Alterations to dwelling under construction. Amendment to approval LY/2/10/ (this application falls within the South Downs National Park Authority)

Thelton House Apartments Crossbush Lane Crossbush Arundel

Thank you for your internet representation made on 6th November 2011 which has been recorded as **an objection** with the comments as follows:

Address	Thelton House Apartments Crossbush Lane, Arundel, West Sussex
Project	Proposed Alterations to Building Under Construction
Drawing	Floor Plans, Site Plan and Elevations
Scale	1:100 @ A1
Date	August 2011
Job No.	DA 10 025
Drawing No.	2.22

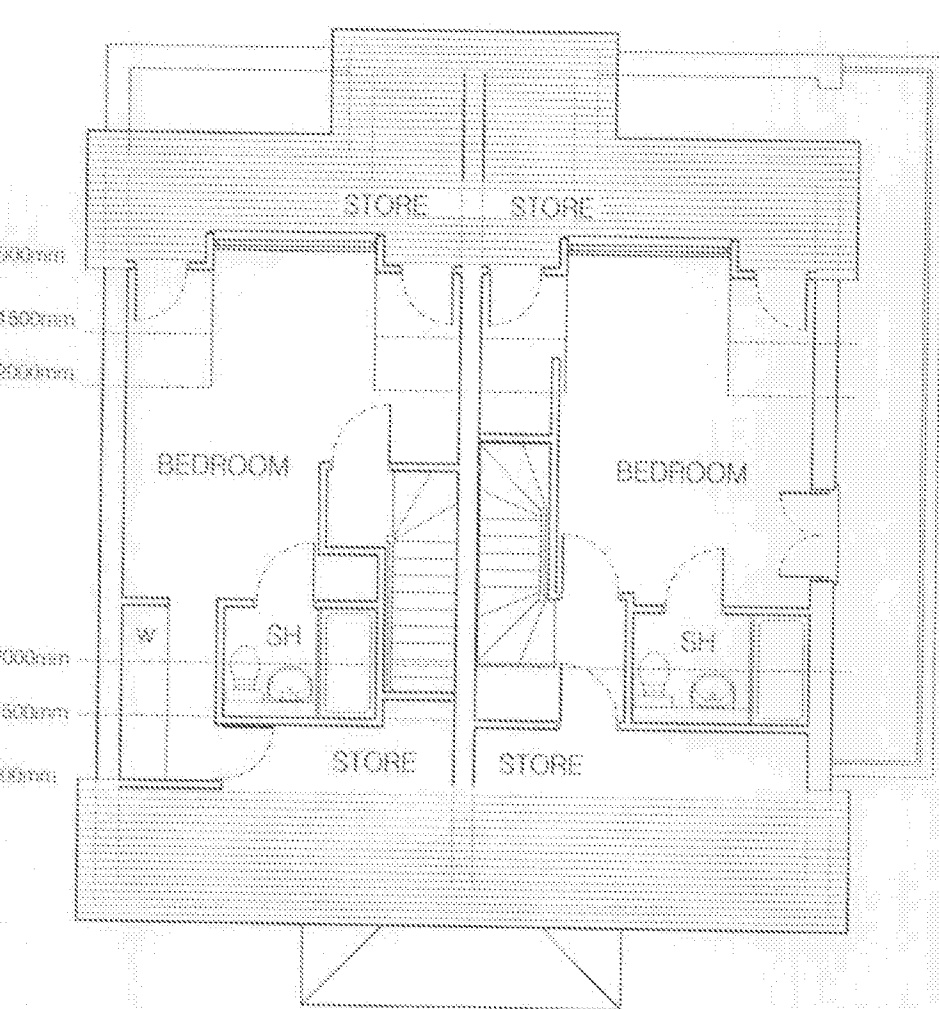
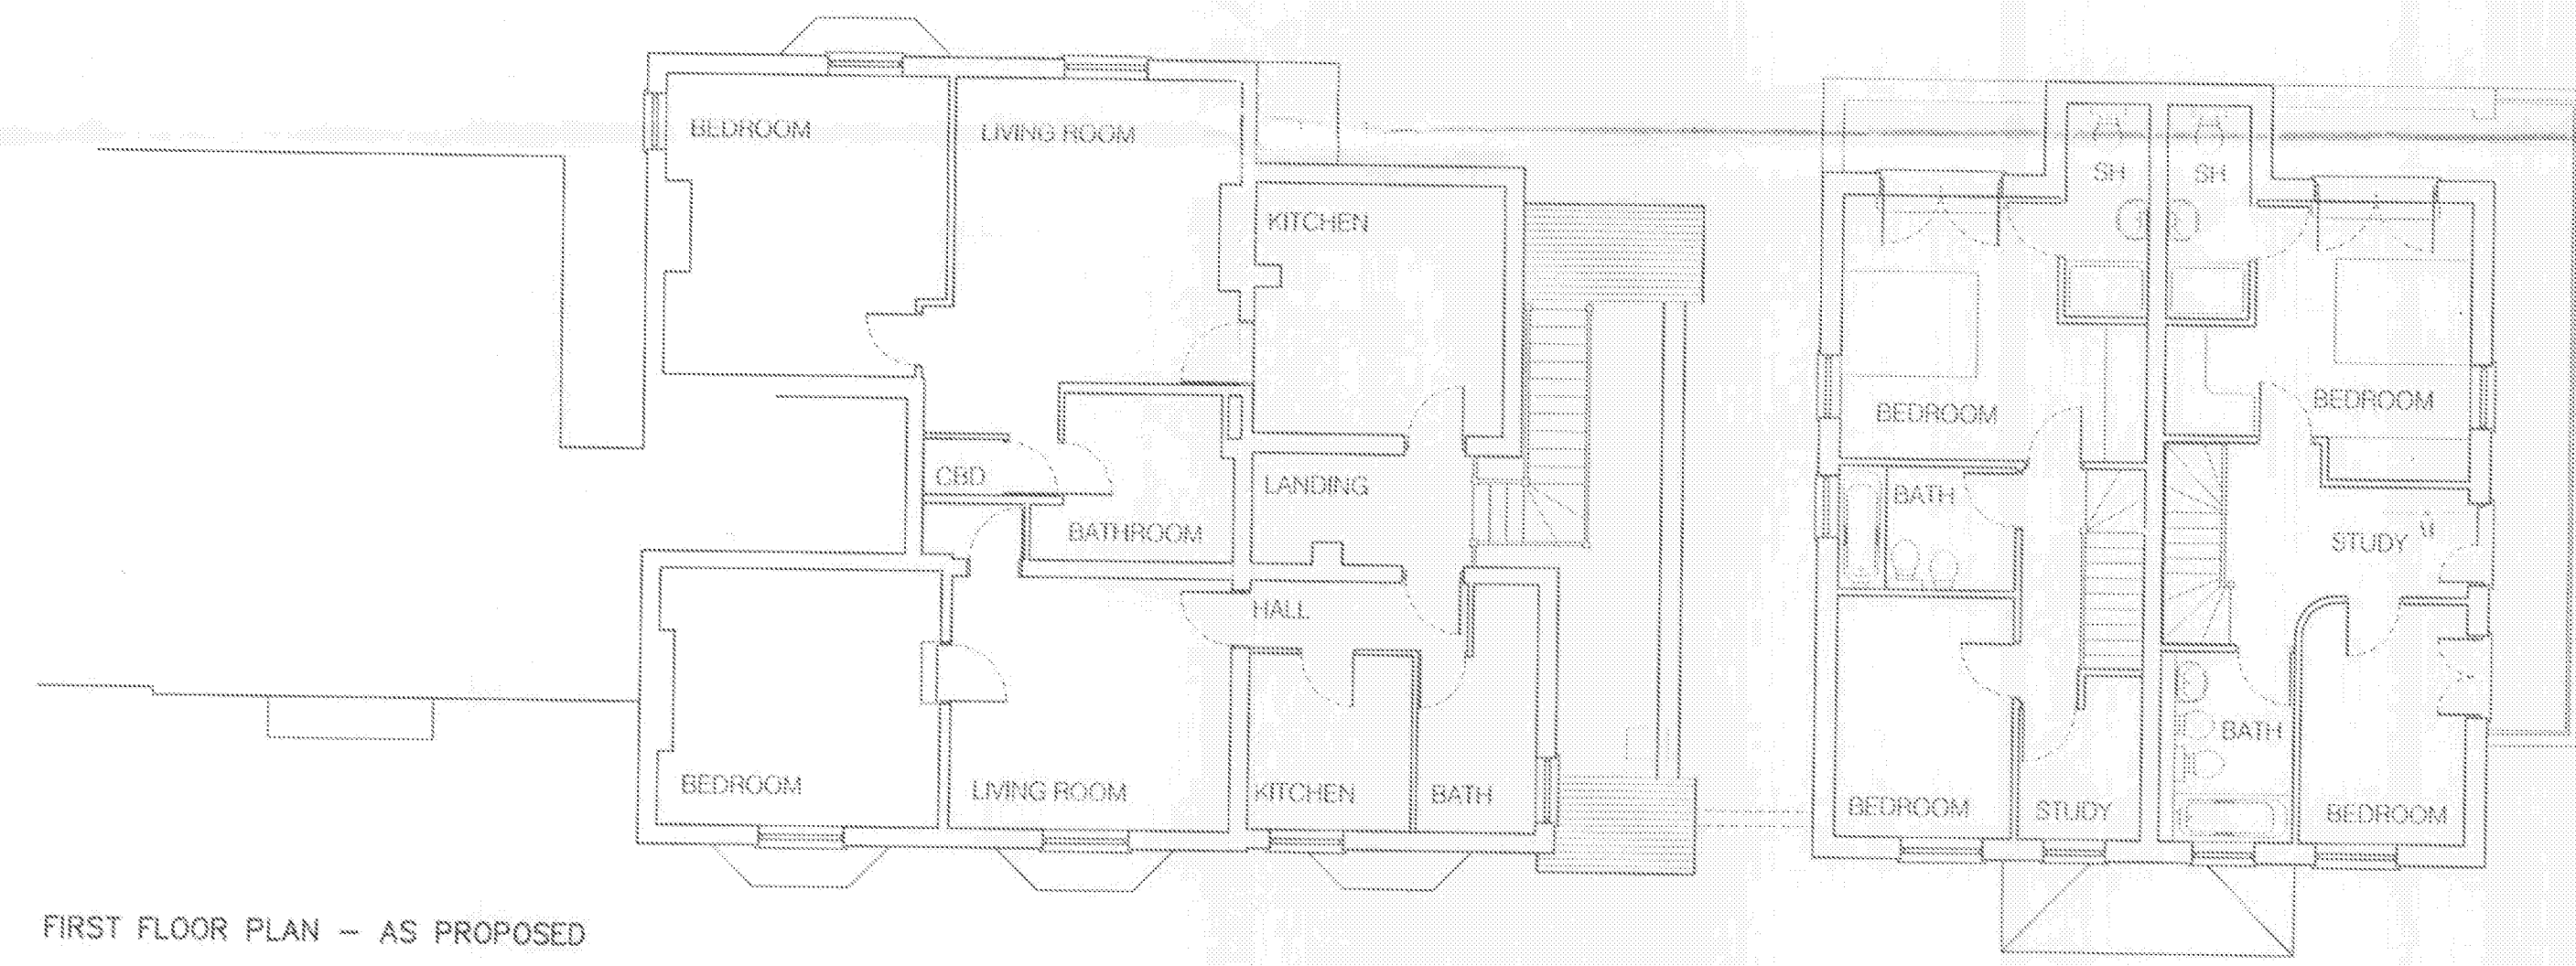
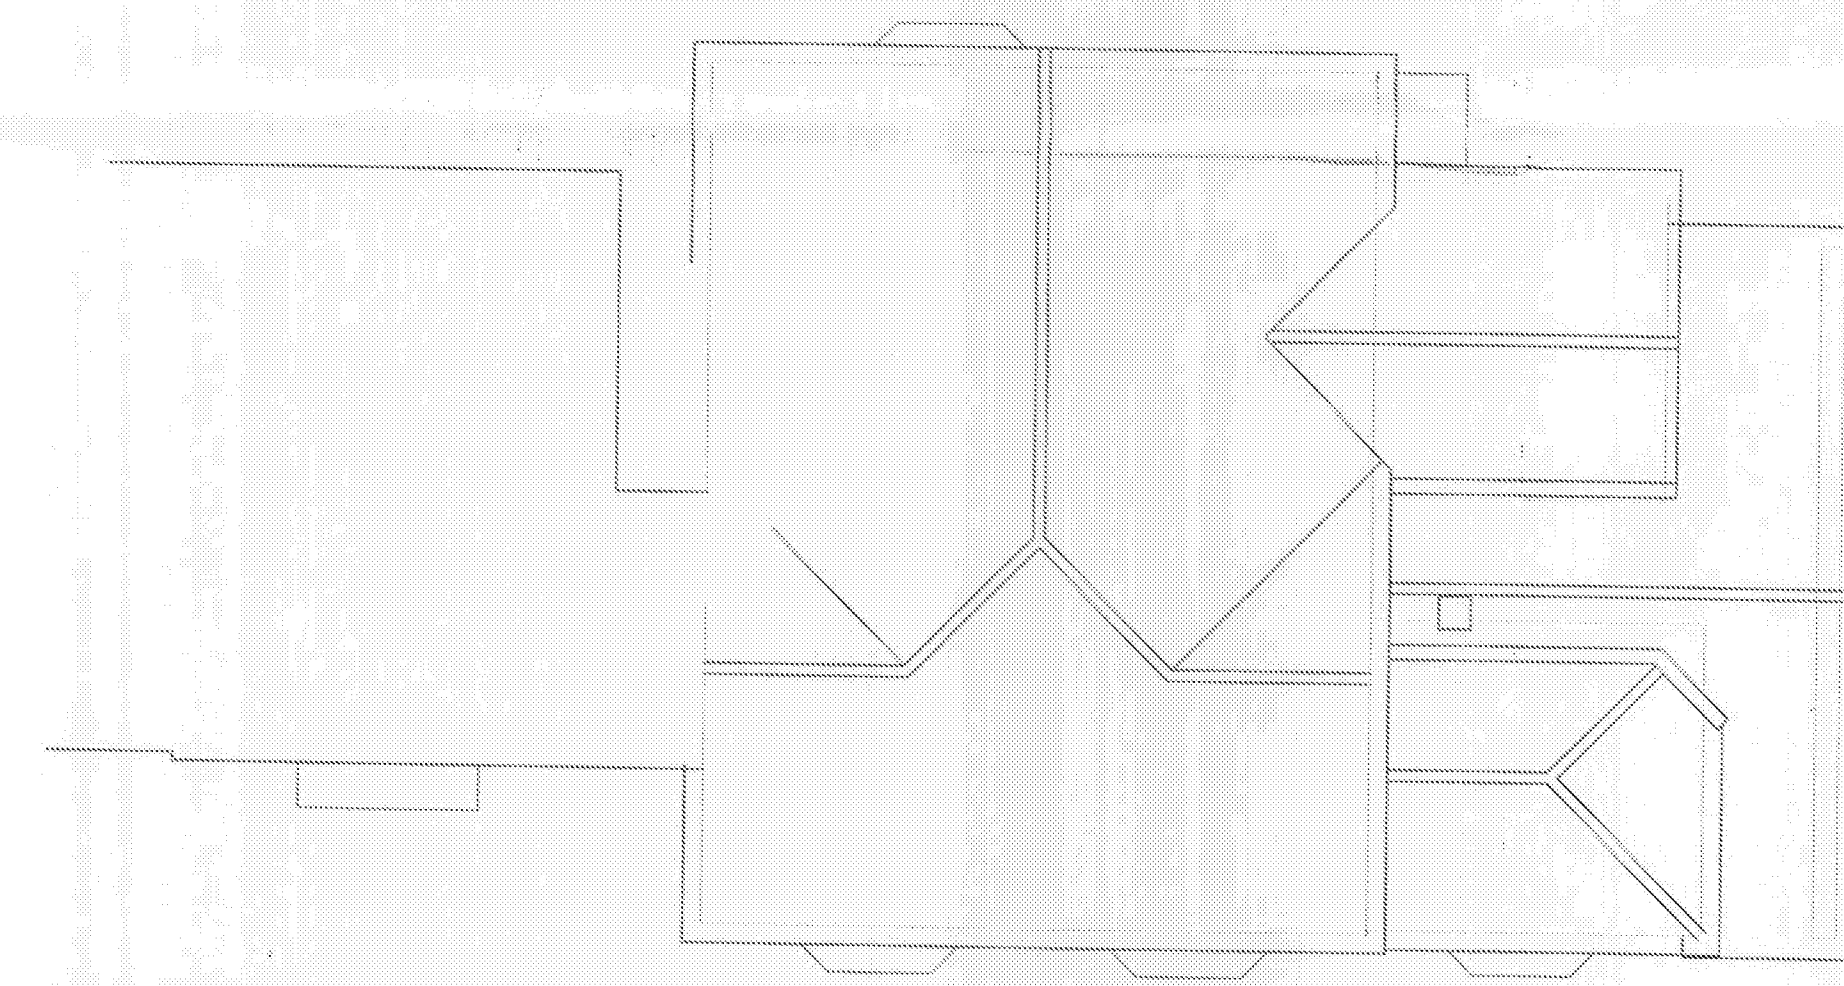
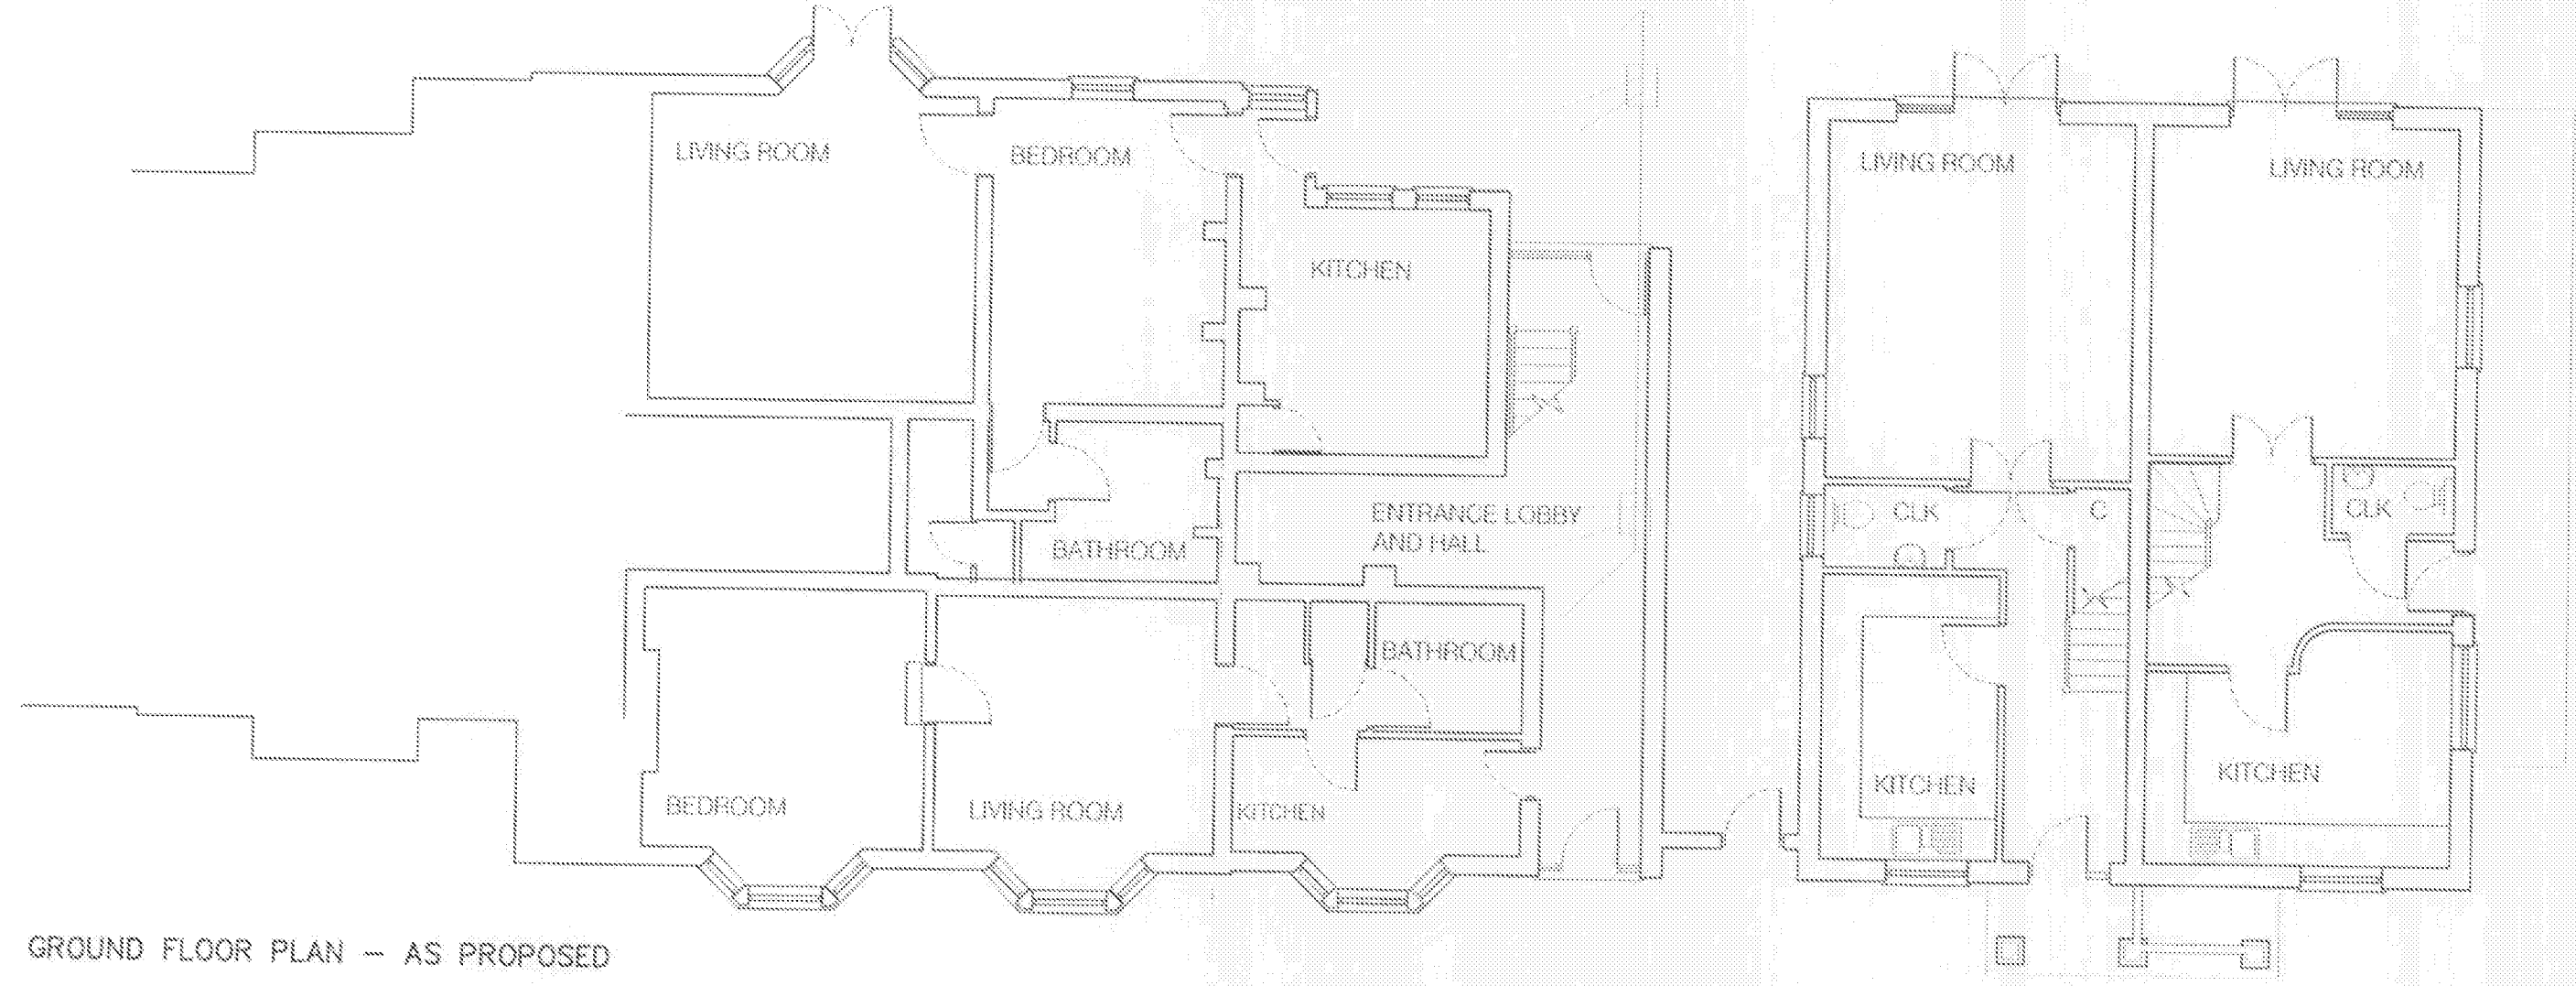
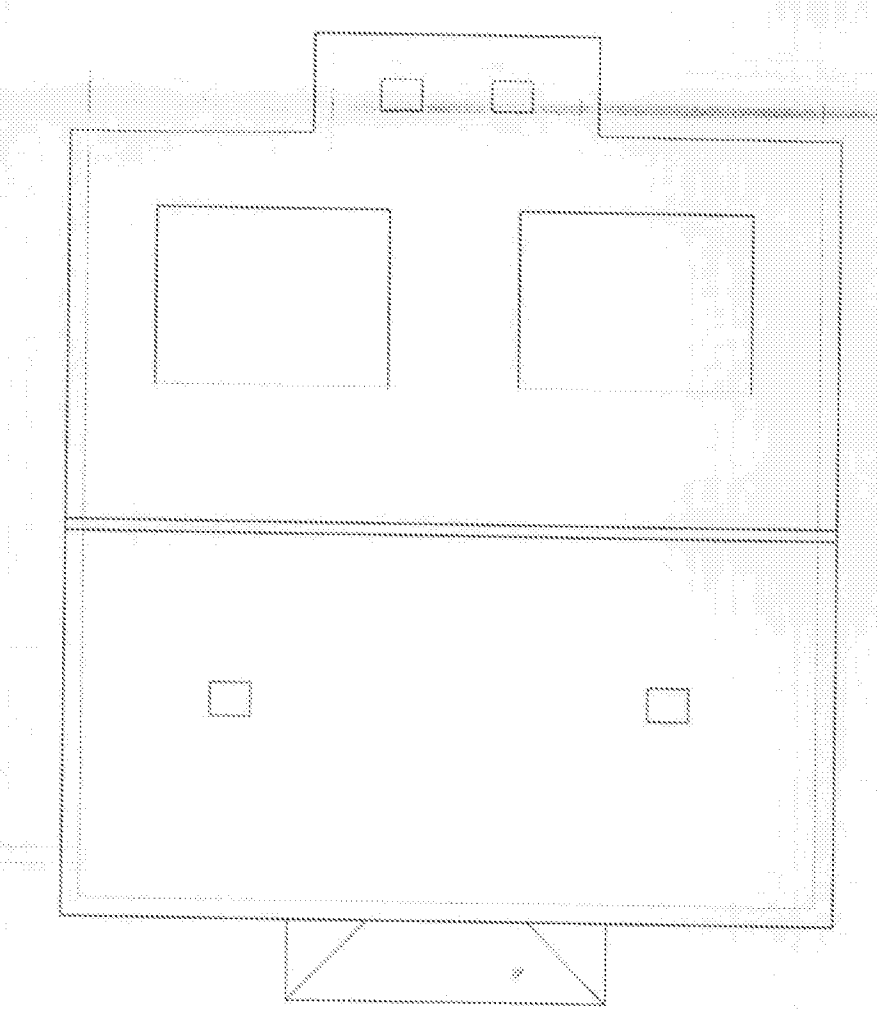
*The introduction of balconies on the West Elevation (WE) and South Elevation (SE) are at odds with whole design of the house; it is not in keeping with the style of the original house (or style of houses in the area); there is no rationale for the balconies - there is sufficient garden space for the enjoyment of outdoor activities. The material of the WE balcony is not specified.* □

*The alteration of the style of windows on the WE is not in keeping with the style of the house - this was an important design statement. The altered windows on the WE are now full length two of which are now opening doors. I have no objection to the extra light created but I do to the idea of the balcony.* □

*There are extra windows in the roof space (gable on the WE and dormer on the SE). This seems as if this is creating a new habitable room - possibly bedroom. This is not part of the original plan and the demand for extra parking facility has not been taken into account.*

*This might involve spilling over to an already narrow road. The windows to on the SE overlook adjacent properties. The level of the dormer windows is higher than any of those in the original house and therefore at odds with the cohesion in "look" of the properties.* □

*In summary: I do not consider these are minor alterations: the introduction of balconies is at odds with this style of house and its adjacent (original Victorian?) property and there is no rationale for them. The style of the windows is at odds with the original house. The introduction of a new habitable room has not been taken into account in assessment of the parking facilities.* □
